From: James Thompson [REDACTED]
Sent: 31 October 2019 12:16
To: Daun Johnson <Daun.Johnson@arun.gov.uk>
Cc: Adam King [REDACTED]
Subject: RE: A/146/19/PL - Revised Planning Drawing

From: James Thompson [REDACTED]
Sent: 25 October 2019 15:14
To: Planning <Planning@arun.gov.uk>
Cc: Adam King [REDACTED]
Subject: A/146/19/PL - Revised Planning Drawing

Further to our telephone conversation please see attached the revised planning drawing for the purposes of validating the application for Land rear of 1 The Heathers, Arundel Road, Angmering.

Job No	Drawing No	Rev
LGC Bungalow	001	P3

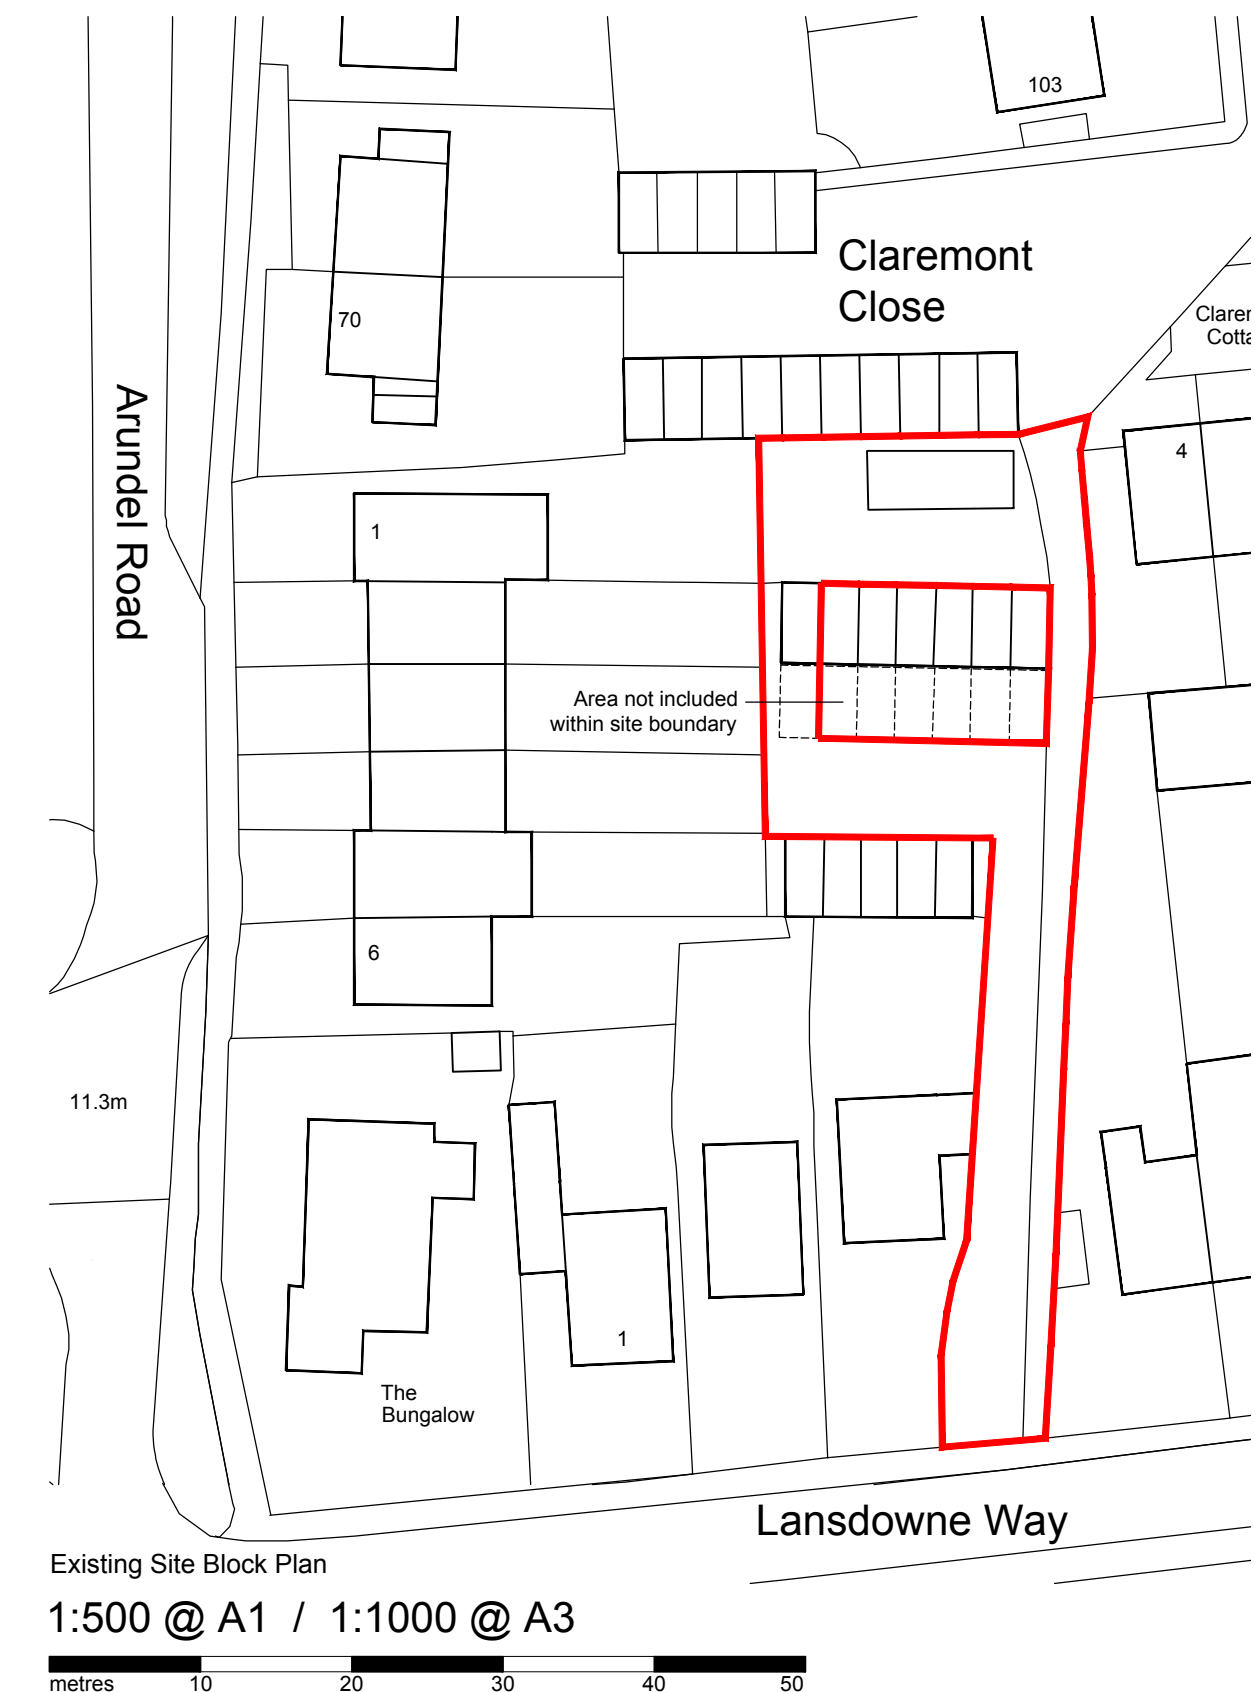
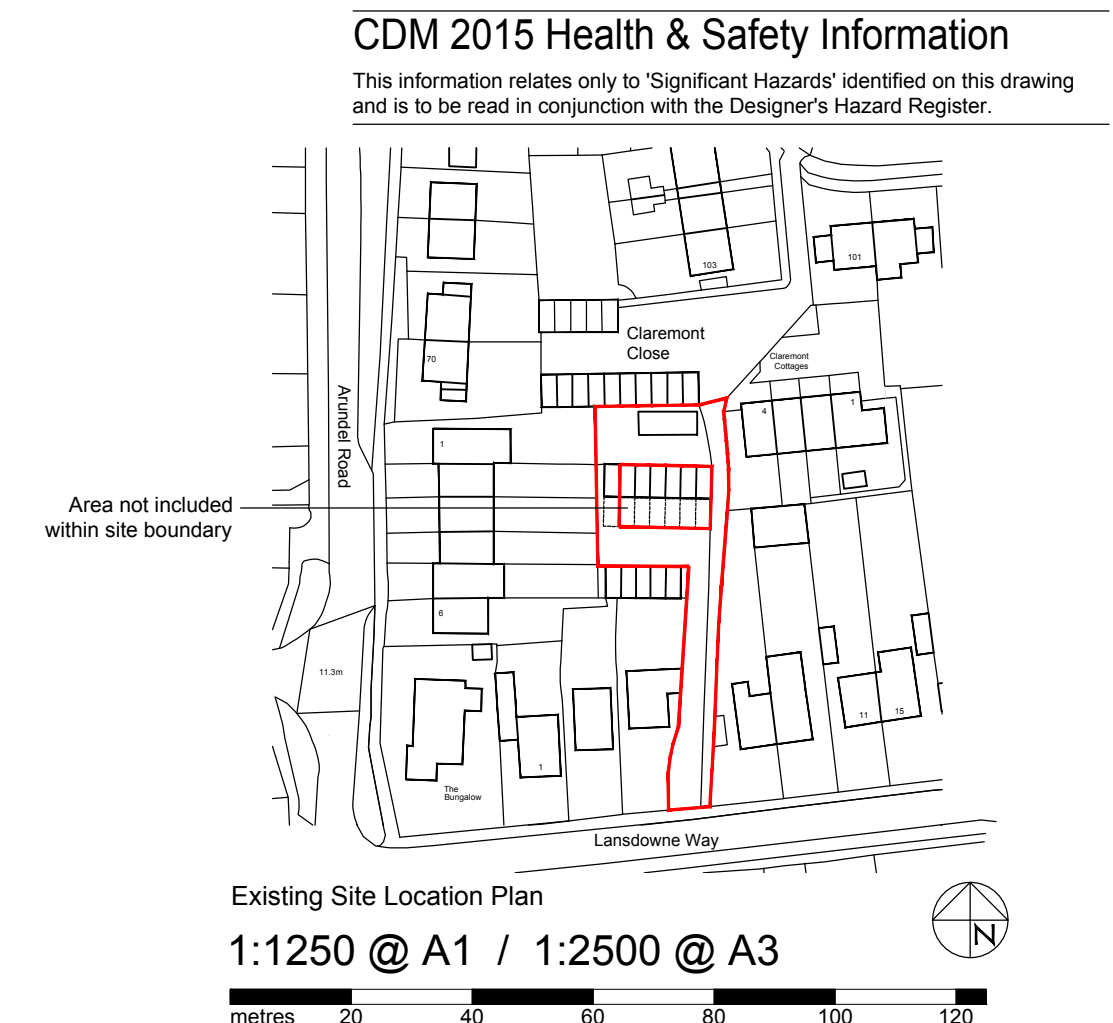
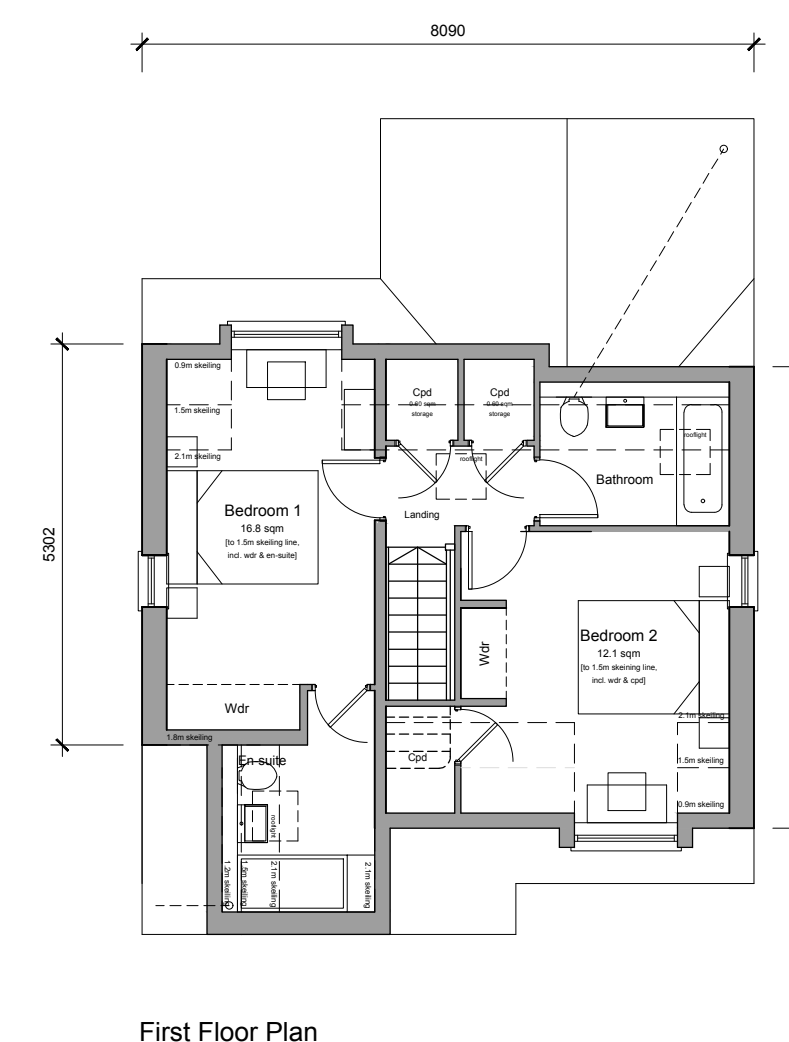
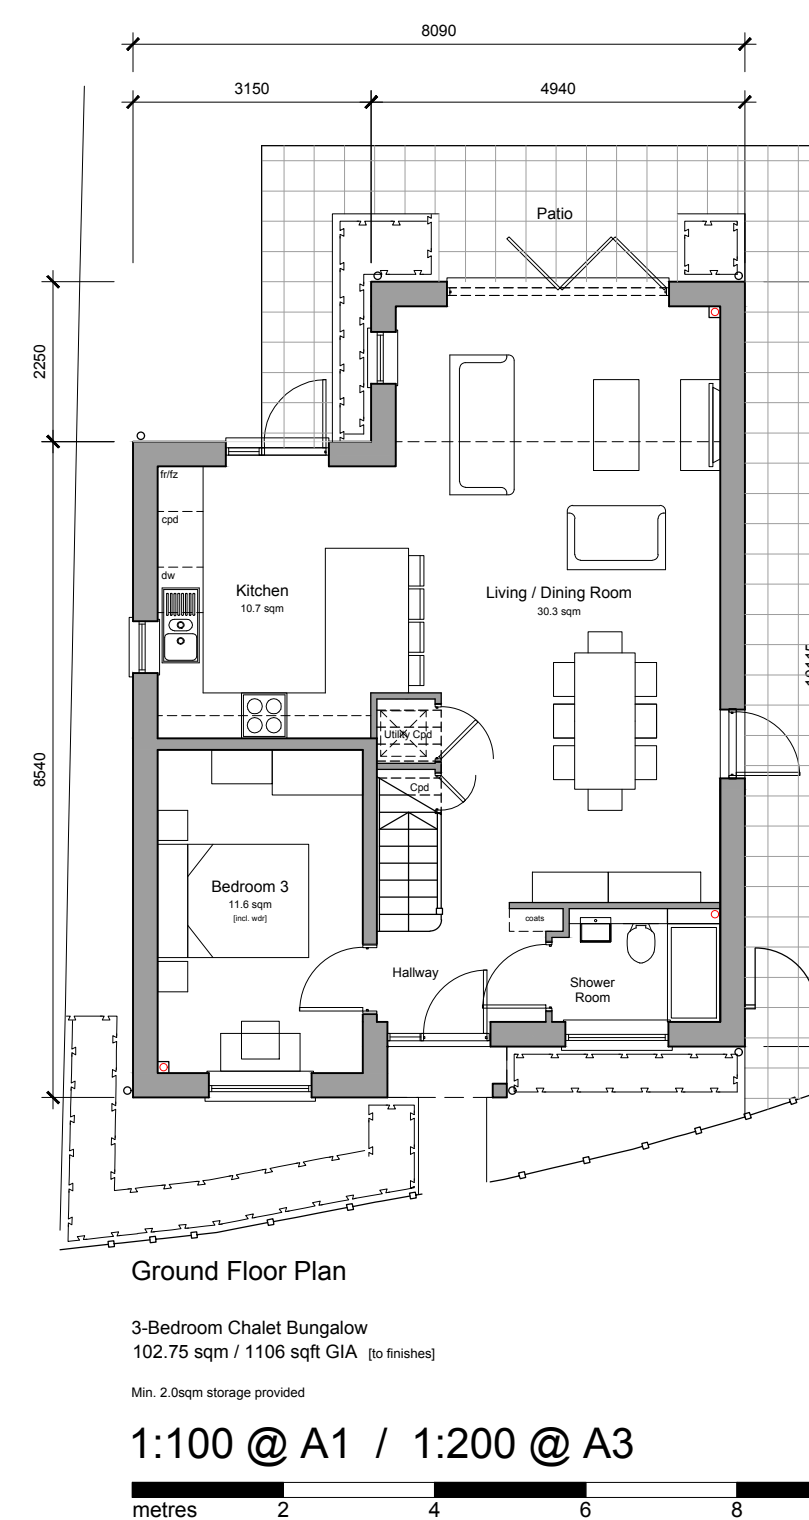
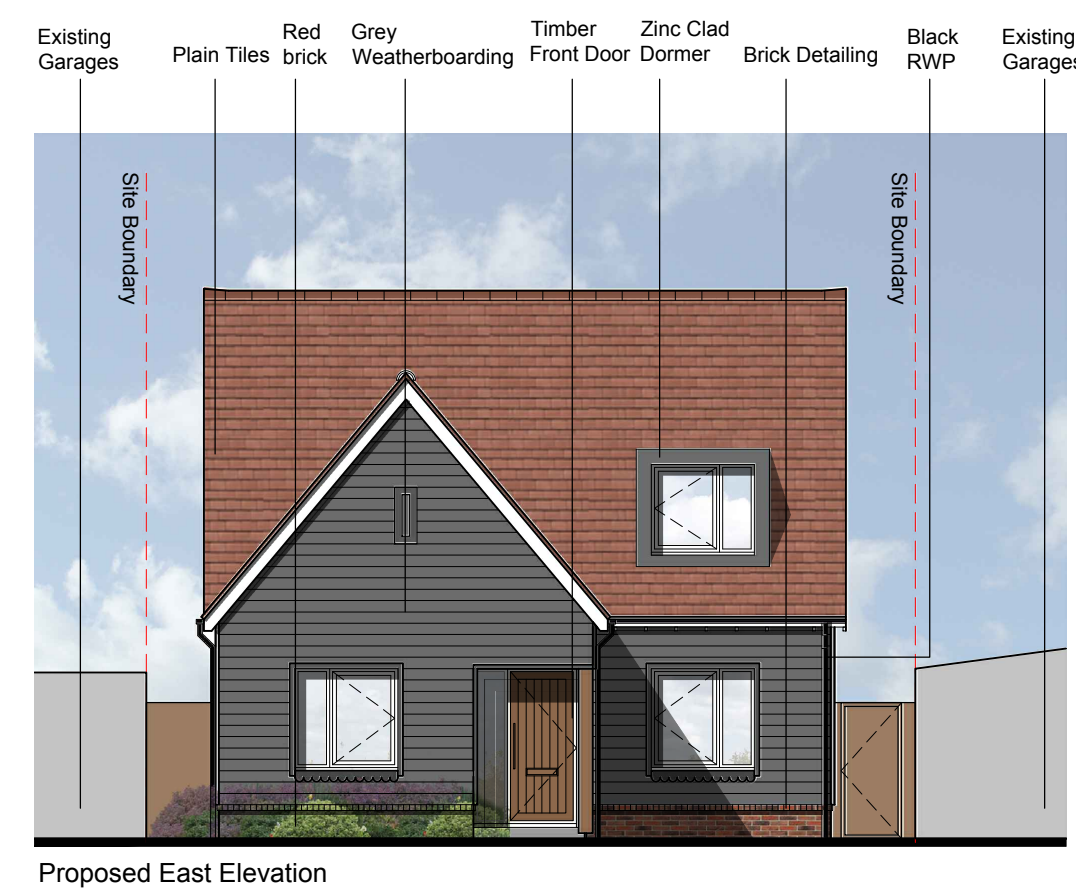
On the location, block and site plans, please annotate the garages, where you have added the red edge around, that the space does not form part of the application.

Also, on the original plans the garage south west of the site was to be used by the applicants but on the new plans, the garage is not within the red edge. Please confirm if the garage is to be in the red edge as the original plans showed because in the DAS, it is stated that '...one of which will be utilised to serve the new dwelling'.

Further to our conversation on Friday, the garages have been annotated in the updated drawing attached which as discussed over the phone addresses the first and final point of your email below.
